From: Thomas Callaway
Sent: 22 July 2015 16:38
To: Planning.Responses
Subject: RE: Planning Consultation on: M/56/15/HH

APPLICATION M/56/15/HH

Site Address: 31 Sea Way Middleton-on-Sea PO22 7RZ

Description of Works: Side & rear extensions

ROOF PLAN
1.100

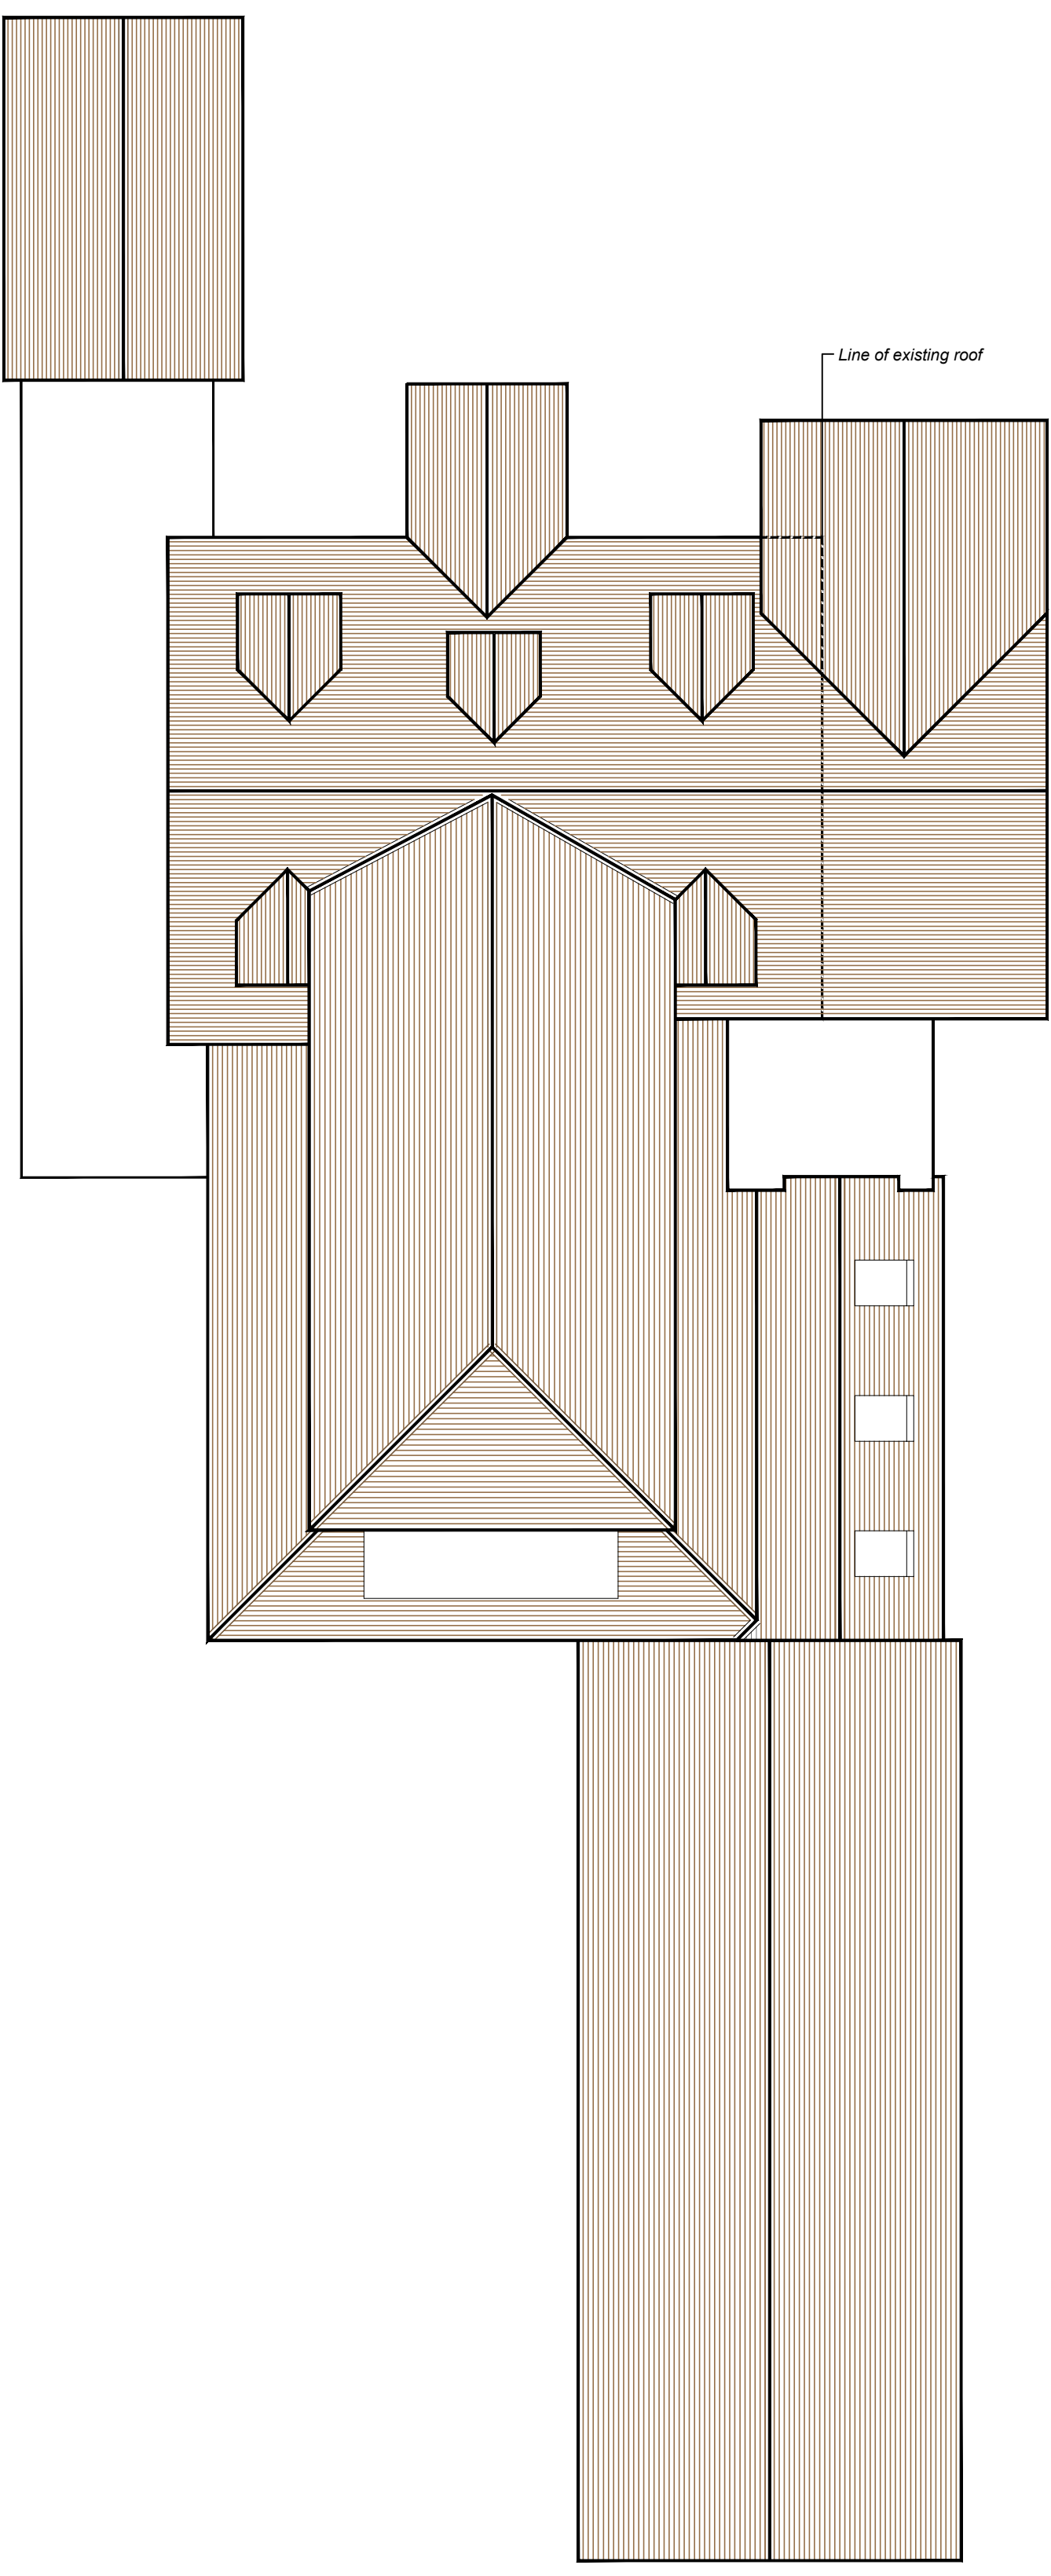
The proposals include building over or close to a culverted watercourse. There should be a three metre easement for access and maintenance of the land drain, which would not be possible if these proposals are approved.

Apply ENGD6A or consider this an objection if layout cannot be altered to suit the requirements of the condition.
